CITY OF ALBUQUERQUE

July 10, 2017

**RE: Ladera Crossing Self Storage
Grading Plan
Stamp Date: No Stamp Date
Hydrology File: J09D026 4090028**

Based upon the information provided in your submittal received 6/30/2017, the Grading Plan **is not** approved for Building Permit. The following comments need to be addressed for approval of the above referenced project:

GRADING & DRAINAGE PLAN

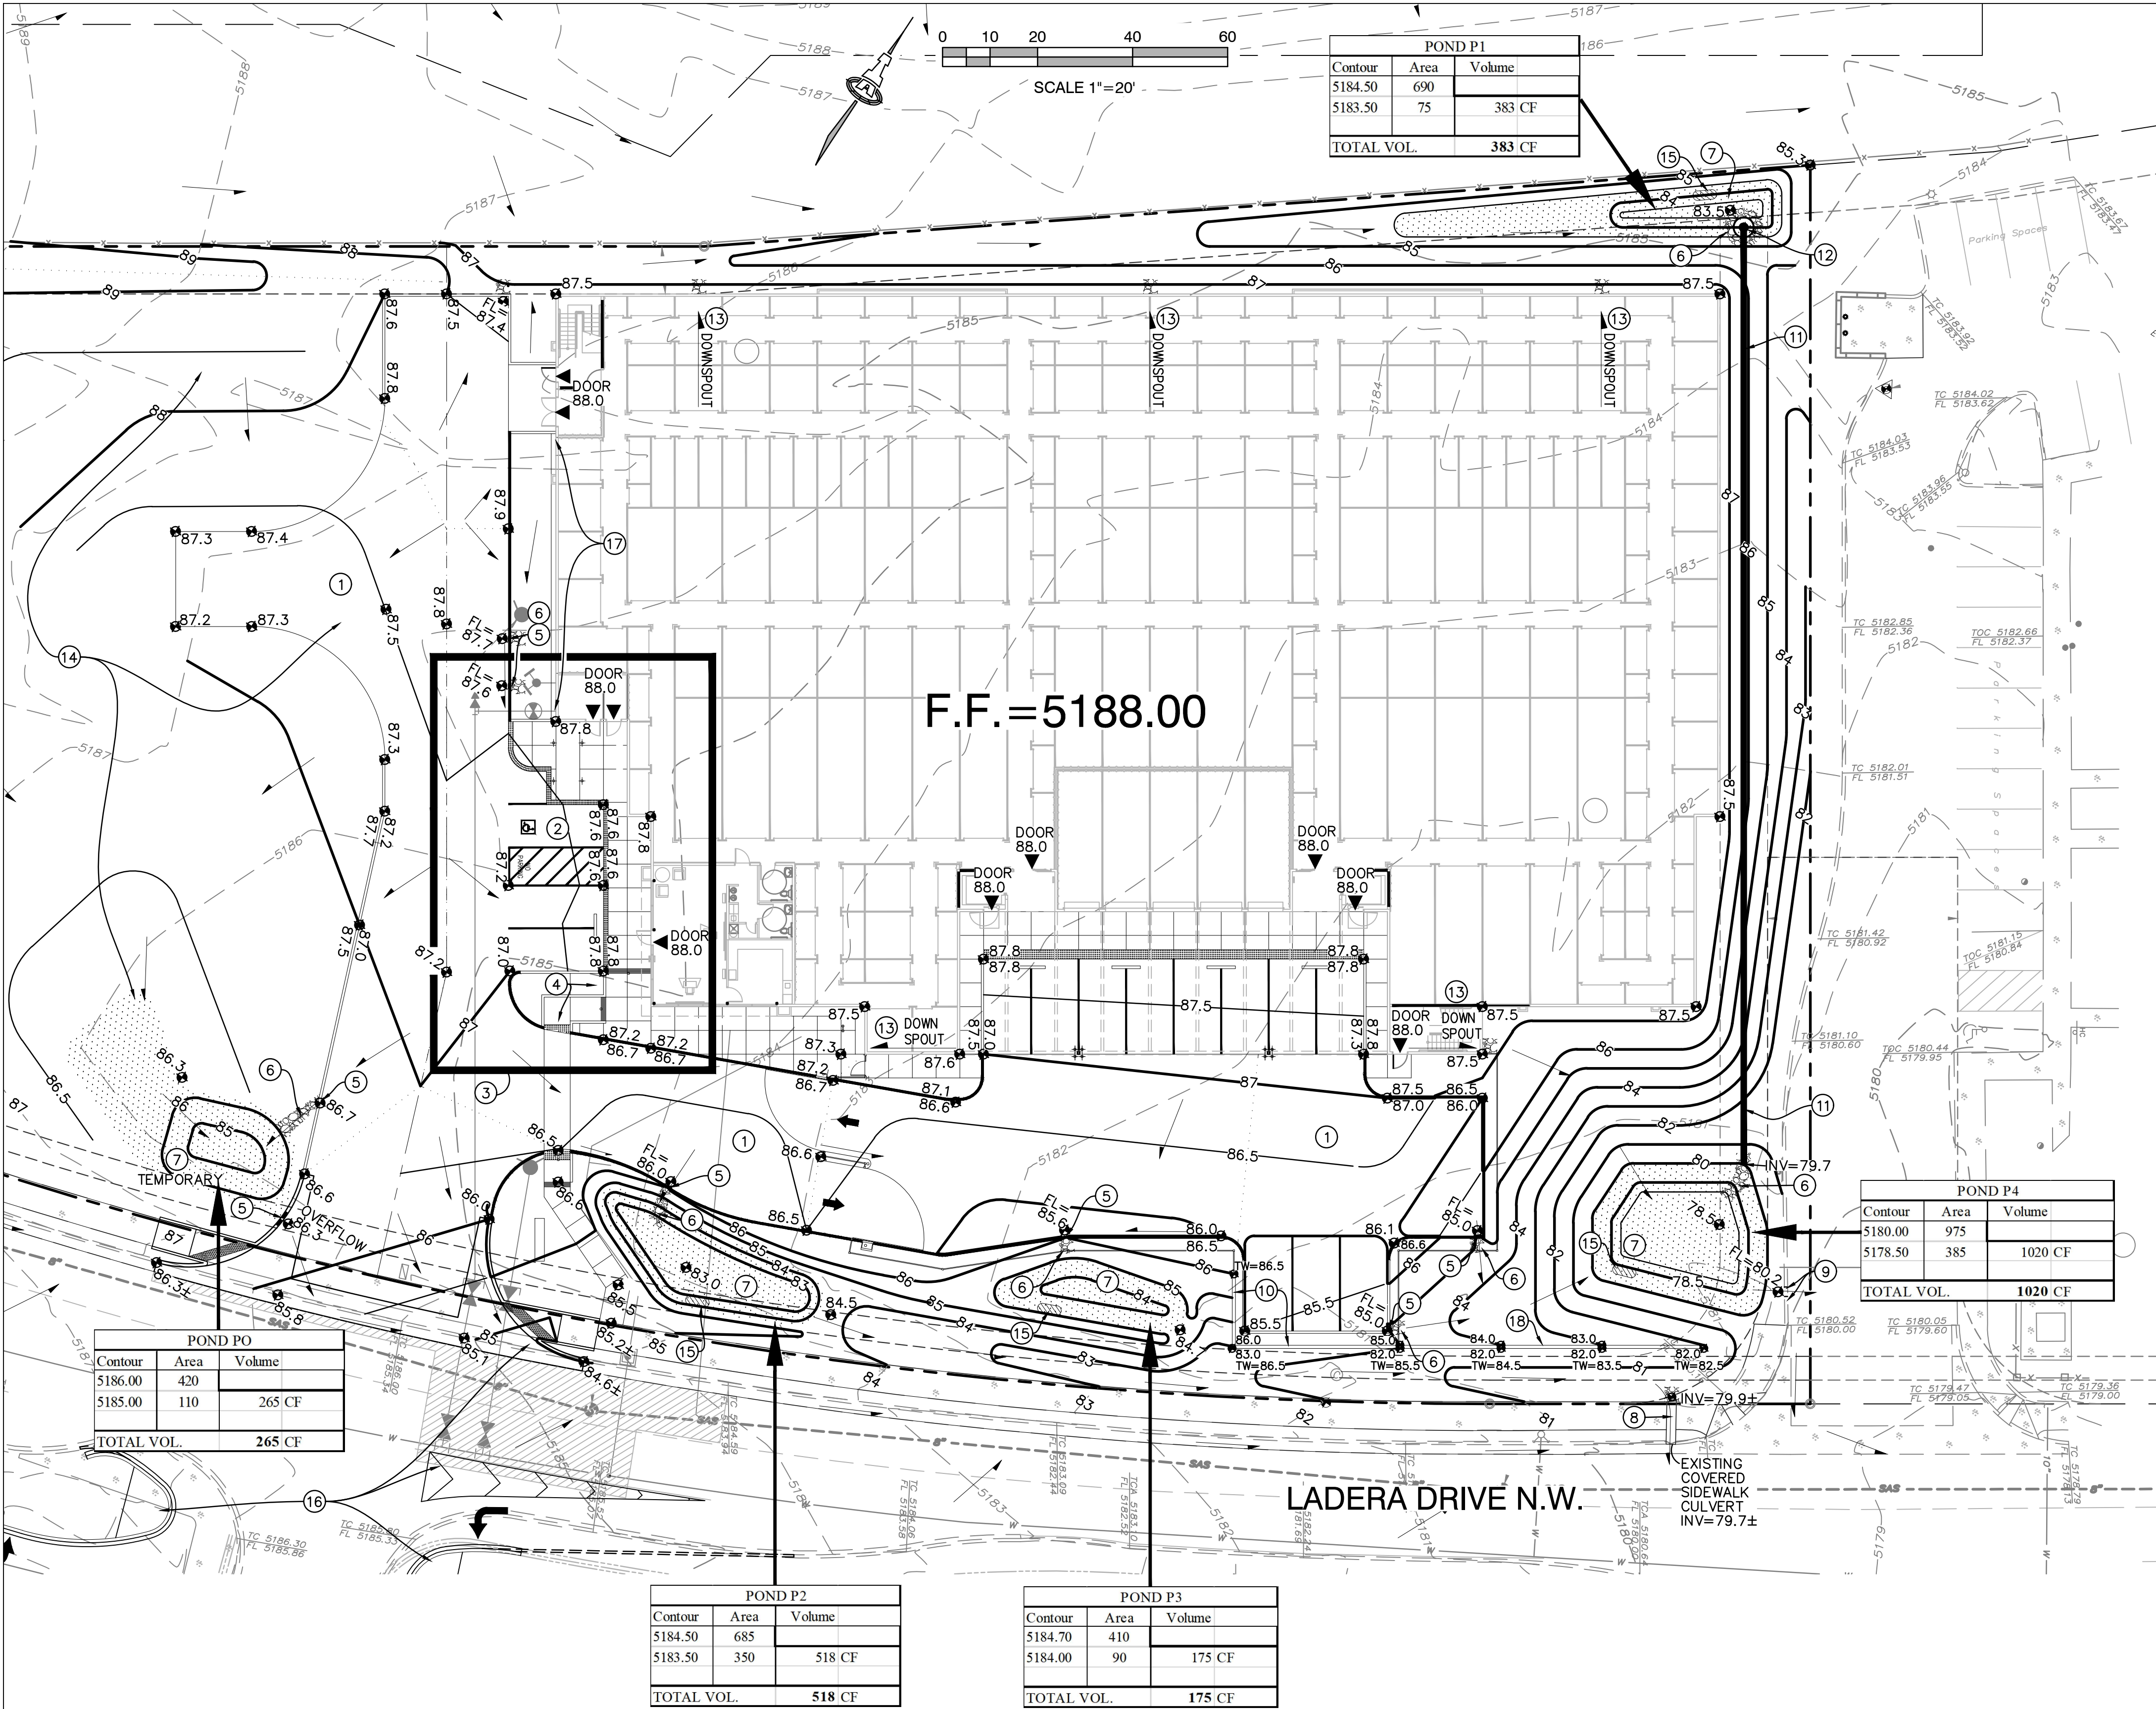
2. Please provide an engineer's stamp with a signature and date.
3. Please remove the word "Conceptual" from the sheet title. A grading and drainage plan is needed for a building permit.

4. This site was included in a drainage study entitled, "Ladera Drive Improvements Gavin Road to Coors Boulevard – Drainage Analysis Memo" by Parsons Brinckerhoff dated August 10, 2015. Please reference this study on the sheet.

5. Please provide the first flush calculations and show each pond volume on the plan at each pond.
6. Please provide the calculation for the sizing of the sedimentation pond at the northeast corner of the site.

7. Please provide the calculation for the sizing of the temp sedimentation/future detention pond.
8. Please provide the weir calculations for the curb cuts.
9. Please provide the pipe size and pipe slope of the proposed drain pipe that connects the sedimentation pond at the northeast corner of the site to the first flush pond in the southeast corner of the site.
10. Please provide the proposed grades at the retaining wall along the south section of the first flush pond in the southeast corner of the site.
11. Please provide a typical detail for the turned CMU block. This block needs to be at least four (4) inches above the proposed grade to avoid clogging.
12. Please provide a Private Facility Drainage Covenant per Chapter 17 of the DPM.
